### **East Anglia One North (EA1N) and East Anglia Two (EA2) Offshore Wind Farms**

**Planning Inspectorate Reference: EA1N – EN010077 & EA2 – EN010078**

**Deadline 5 - 3 February 2021**

**East Suffolk Council's Summary of Oral Case - Issue Specific Hearing 6**

Drawing file: EN010078 / EN010078-001035-2.10 EA2 Important Hedgerows and Tree Preservation Order Plan.pdf

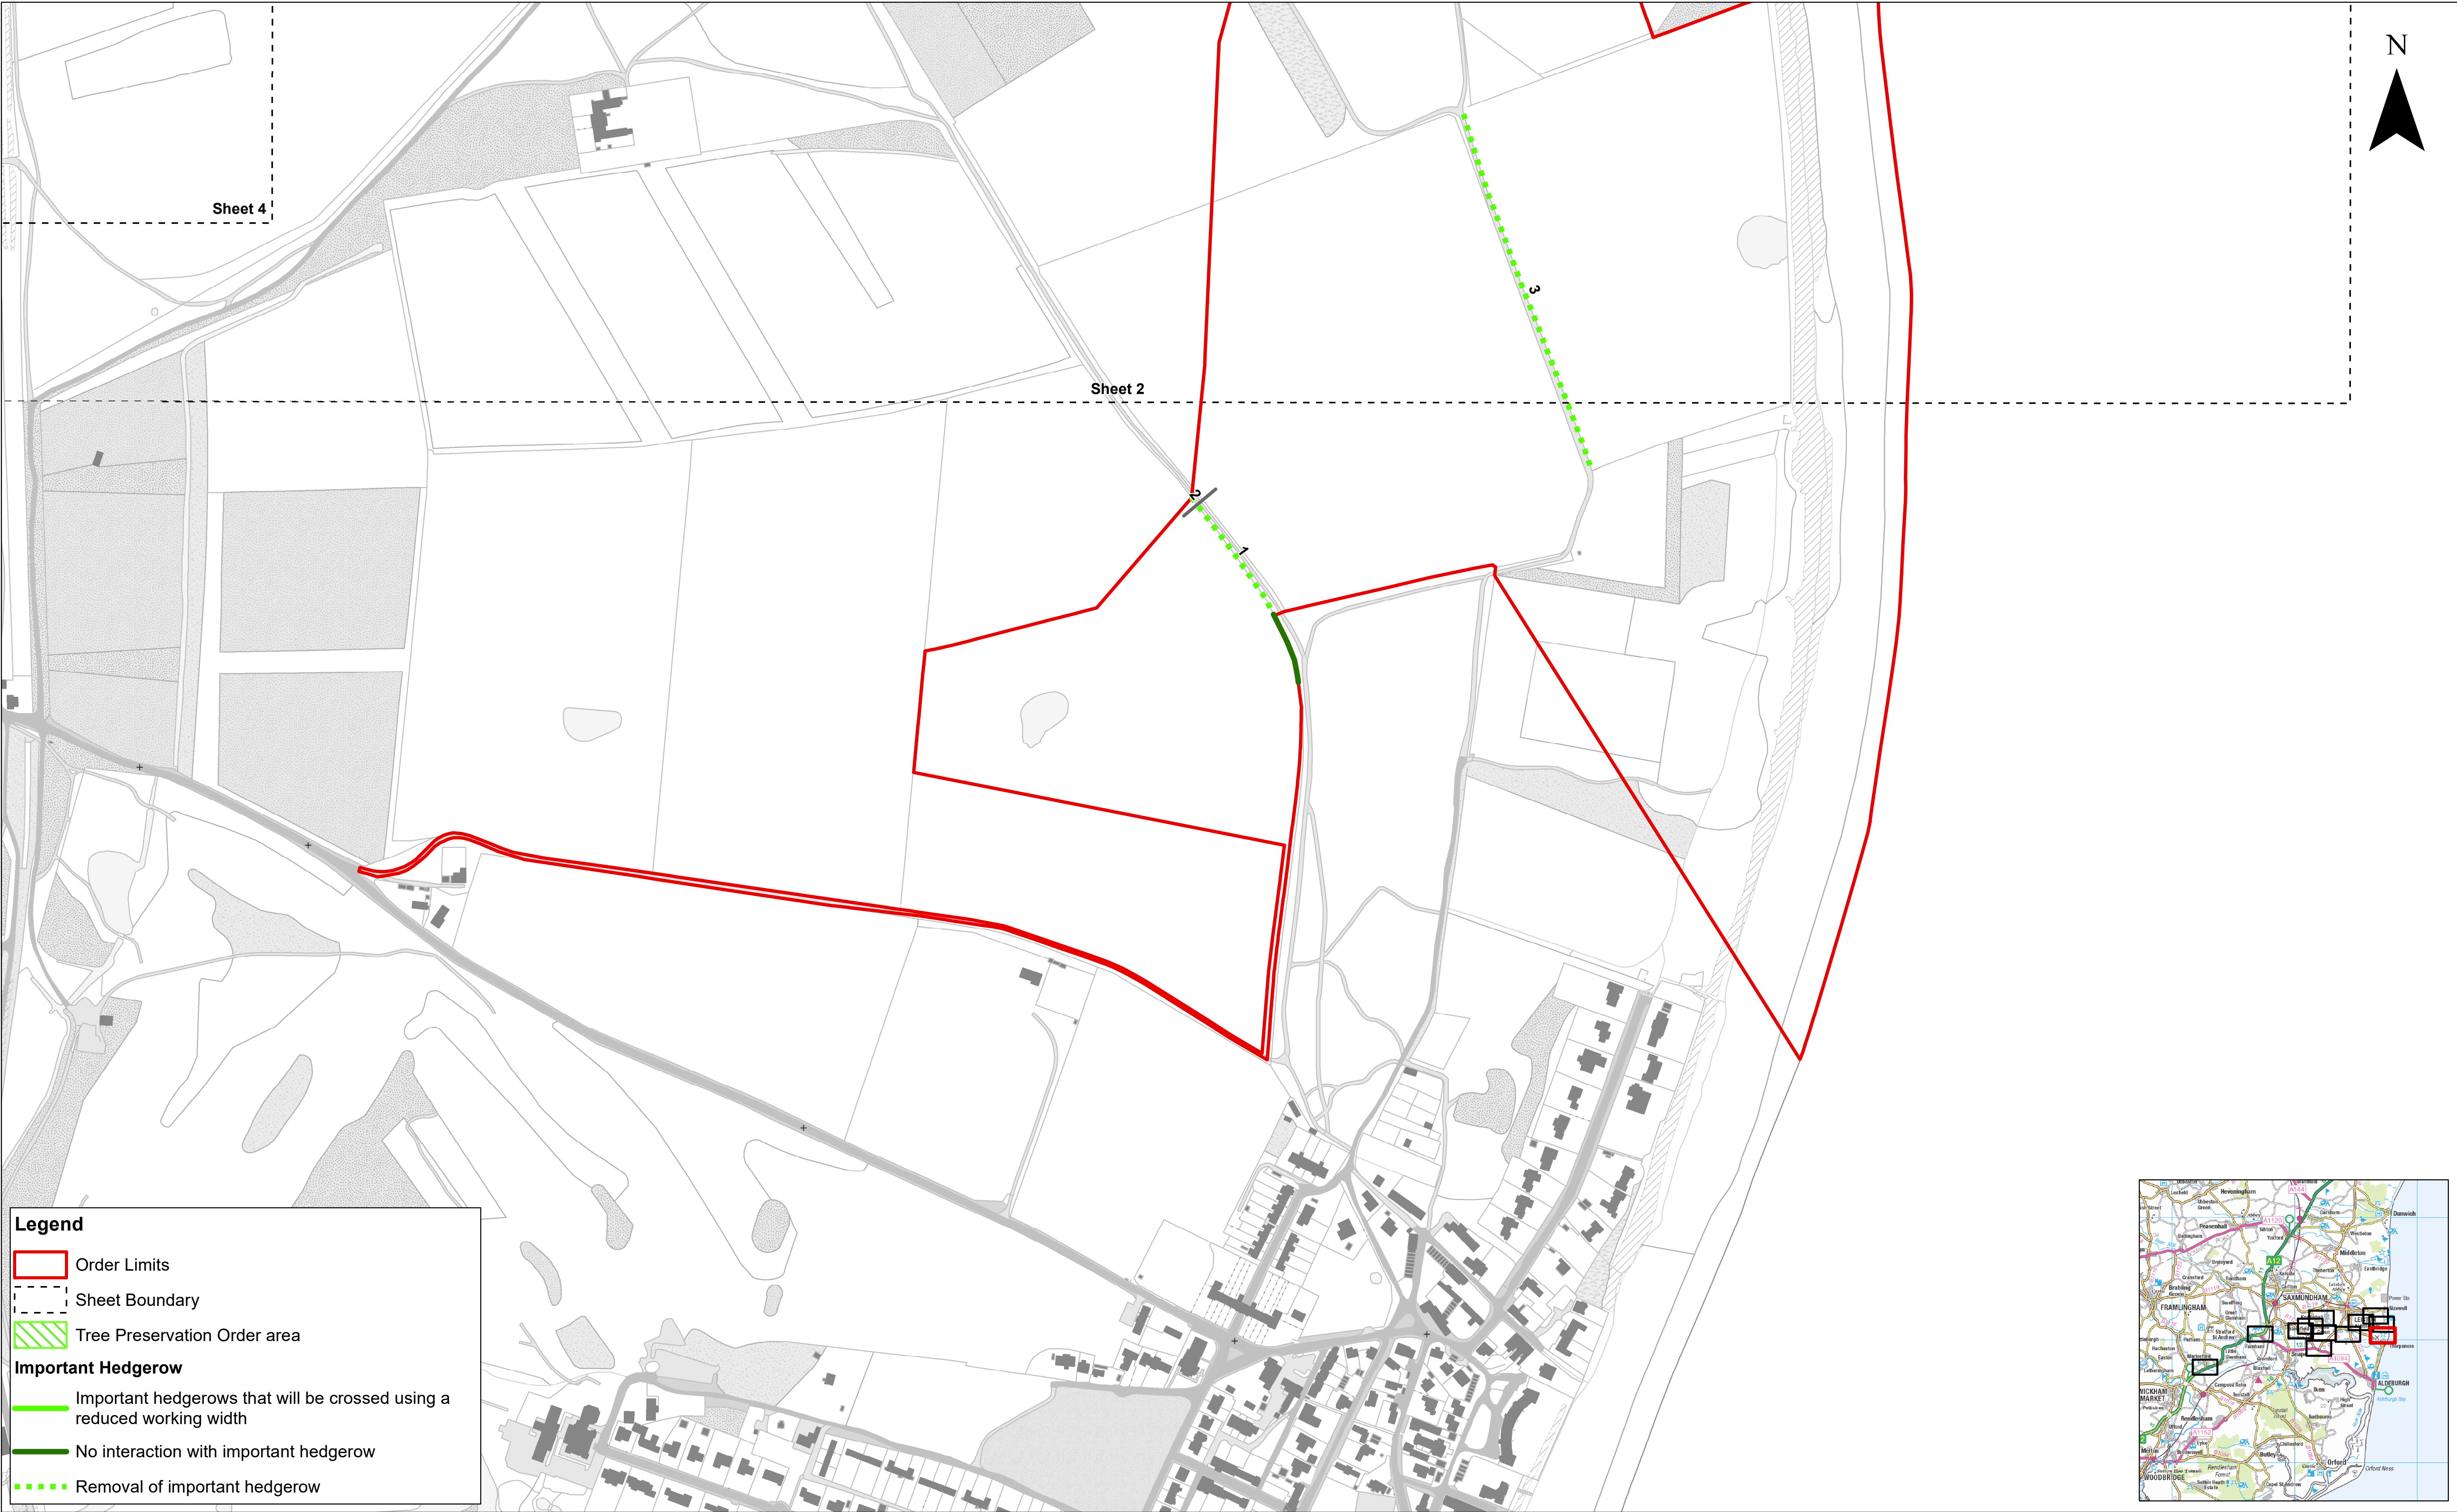
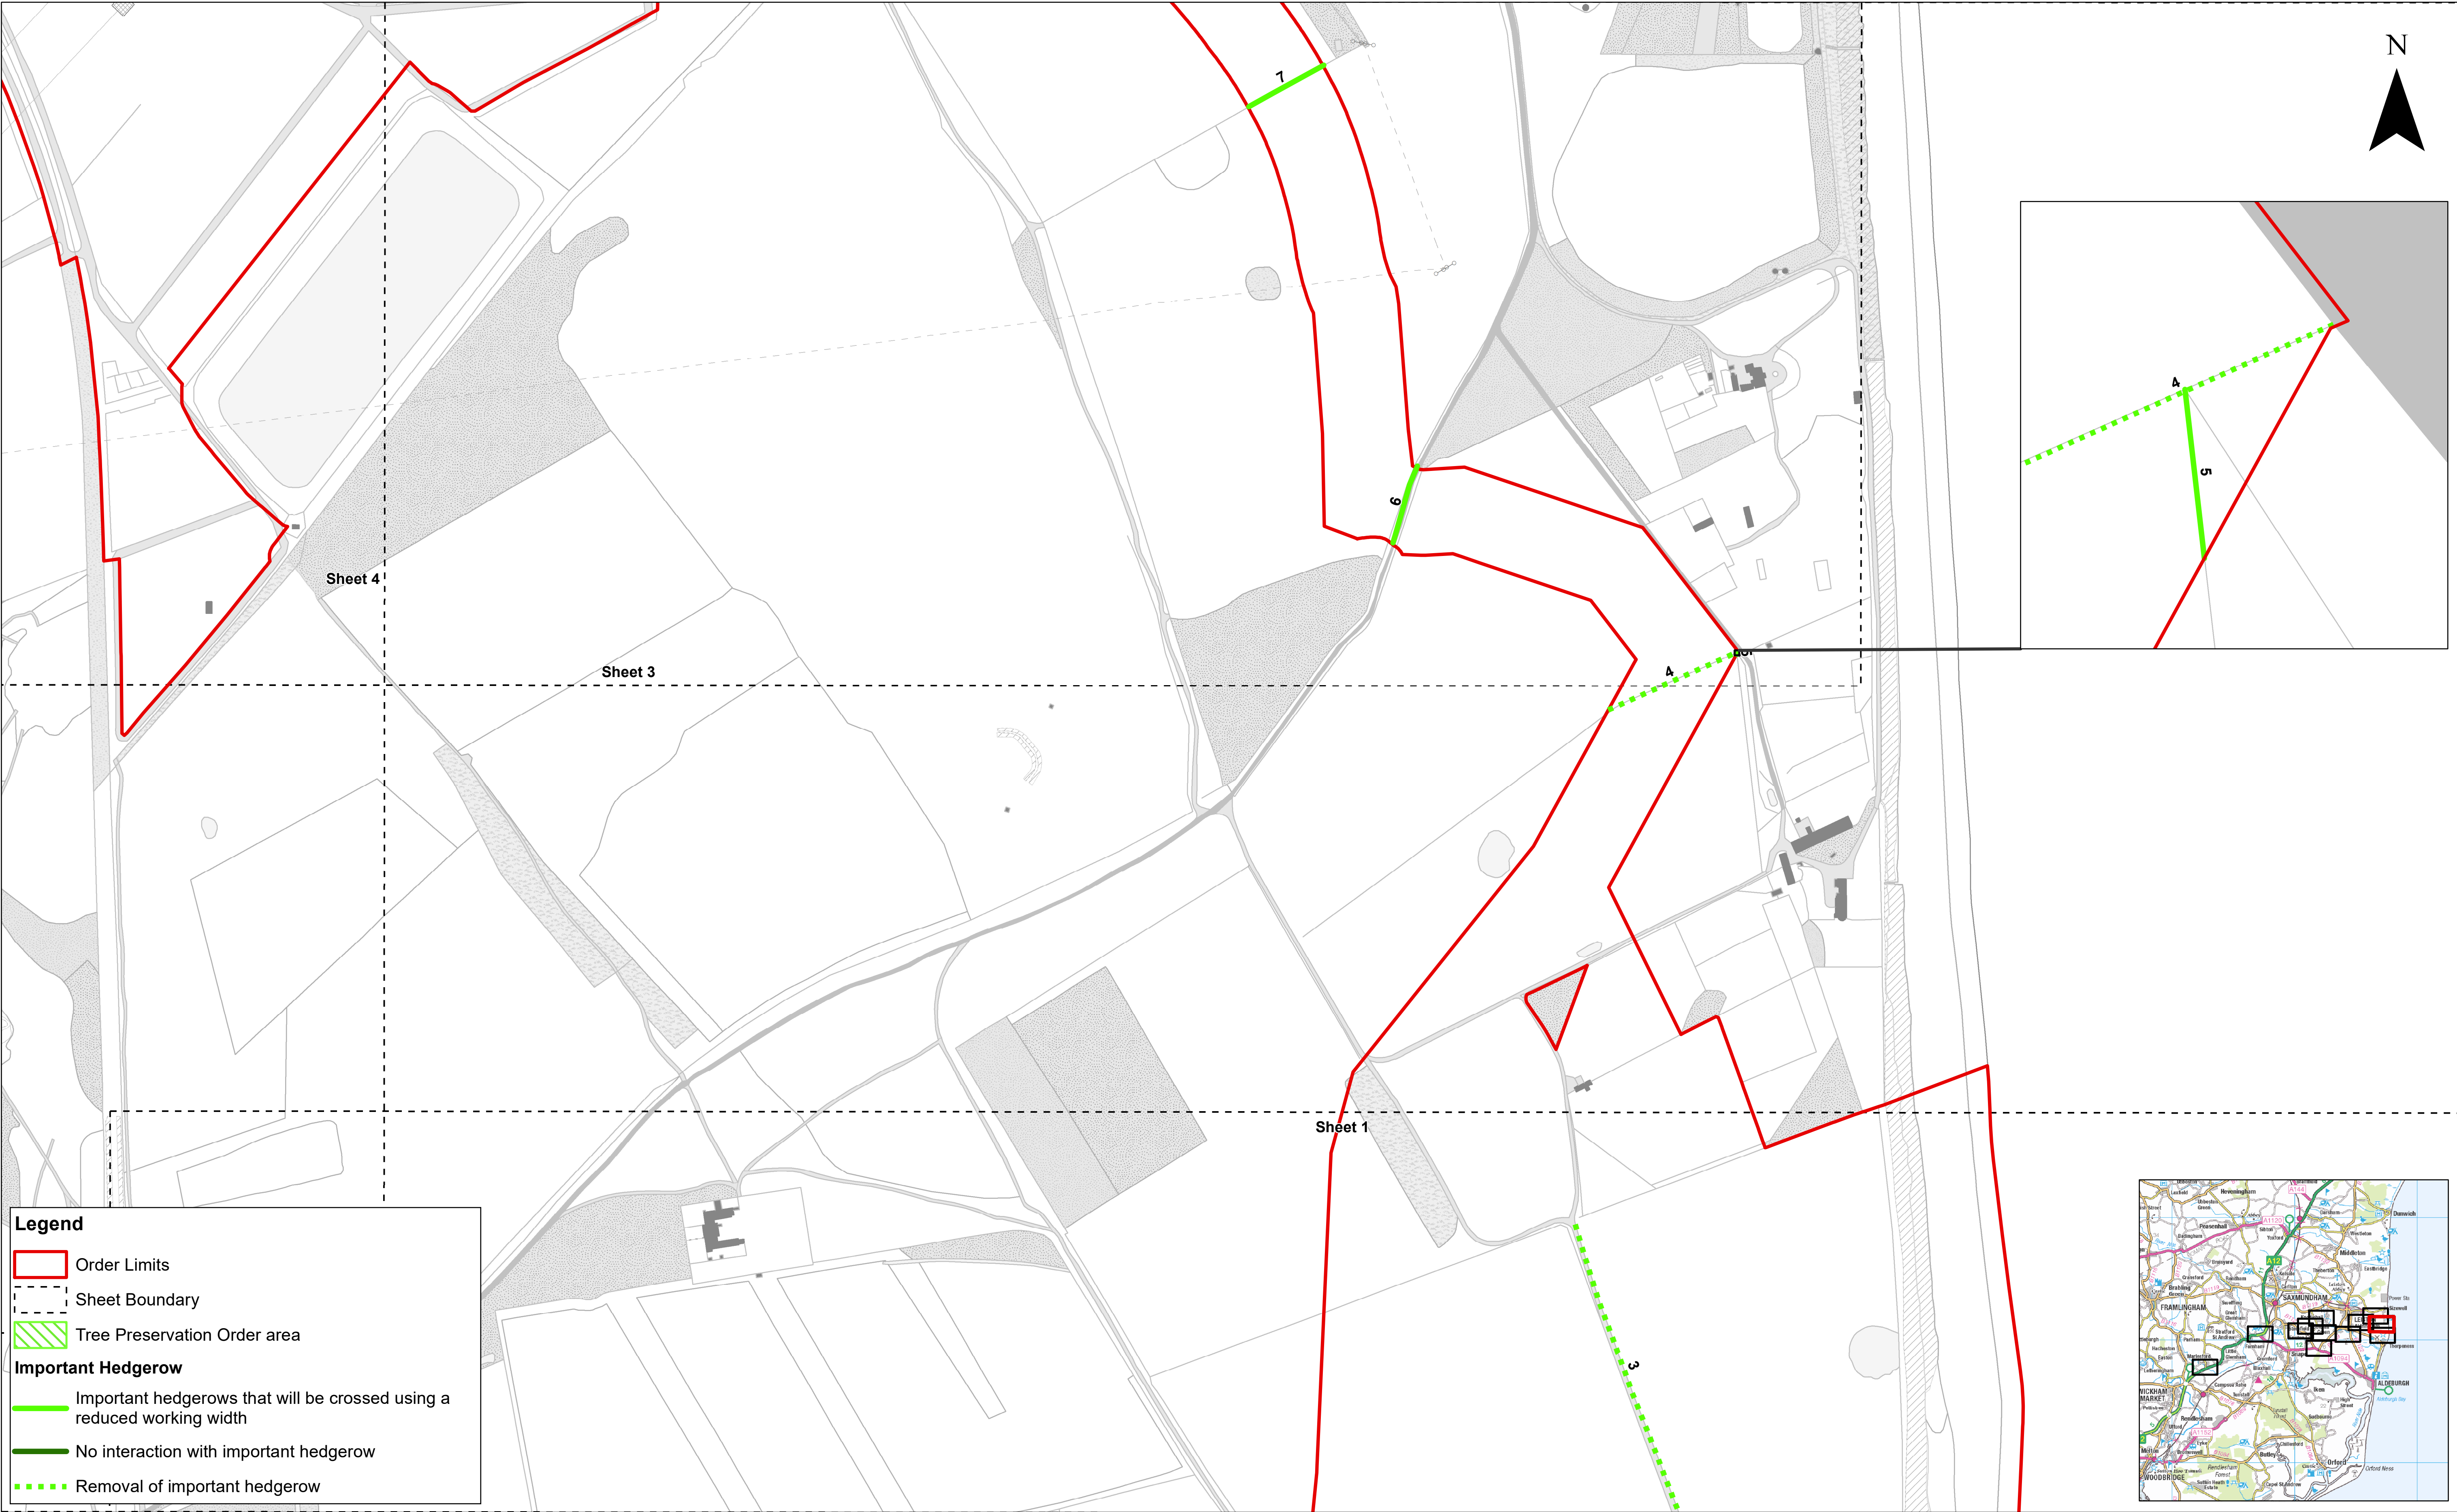
ESC supports SCC and the Applicants submissions in relation to the MoU. It is considered that a requirement is not necessary and could restrict the flexibility and dynamism which the MoU in its current form allows.
Schedule 11 – Hedgerows Part 1 – Removal of Important Hedgerows		<p>ESC seeks clarity regarding the hedgerows identified with Schedule 11 of the draft DCOs.</p> <p>ESC seeks clarity regarding the hedgerows identified within Schedule 11 of the draft DCOs.</p> <p>Hedgerows marked 1 and 2 are identified within Schedule 11 (REP3-011) as being removed but on the Important Hedgerows and Tree Preservation Order Plan (REP3-010) they are identified as being crossed with a reduced width. Annex 1 of the OLEMS document (REP3-030) identifies hedgerows 1 and 2 as being subject to full or partial removal. Clarification on this is required.</p> <p>Clarification is also required in relation to hedgerow marked 28 which is identified on the Important Hedgerows and Tree Preservation Order Plan (REP3-010) as being removed but is not identified within Schedule 11 as being removed and identified in Annex 1 of the OLEMS (REP3-030) as not subject to interaction.</p> <p>The interaction identified within Annex 1 of the OLEMS (REP3-030) in relation to a number of hedgerows does not appear to correspond to the interaction identified within Schedule 11 of the draft DCOs (REP3-011) and the interaction identified on the Important Hedgerows and Tree Preservation Order Plan (REP3-010). Further clarification as to the reasons for this is required. Does Annex 1 identify a greater</p>

number of important hedgerows to be crossed with a reduced width as some of these will be crossed with a width less than 32m but greater than the draft DCOs definition of reduced width which is 16.1m?
<p>Schedule 16 – Procedure for discharge of requirements</p> <p>1 – Applications made for certain approvals</p> <p>2 – Further information</p>		<p>ESC understands that this procedure is set out in Appendix 1 of The Planning Inspectorate's 15: Drafting Development Consent Orders but there have been a number of recent DCOs which have been granted with wording which varies from that set out. ESC is particularly referring to the two latest decisions on offshore windfarms published relating to Hornsea Project Three and Norfolk Vanguard Offshore Wind Farms.</p> <p>Schedule 16 does not include any details in relation to the information the Applicant should provide. For example, the Norfolk Vanguard DCO included the wording:</p> <p><i>"a) the undertaker must give the discharging authority sufficient information to identify the requirement(s) to which the application relates;</i></p> <p><i>"b) the undertaker must provide such particulars, and the request be accompanied by such plans and drawings, as are reasonably considered necessary to deal with the application."</i></p> <p>The Council considers that this would be useful additional wording.</p> <p>1(2)(a) ESC considers that 42 days provides an insufficient standard time period in which to discharge requirements. It is noted that this is the timescale set out in Appendix 1, however a longer period of 56 days is provided when discharging planning application conditions and therefore a shorter period is not considered appropriate. The DCOs and requirements relate to multiple large scale complex developments which will require significant resource from ESC and consultation with</p>
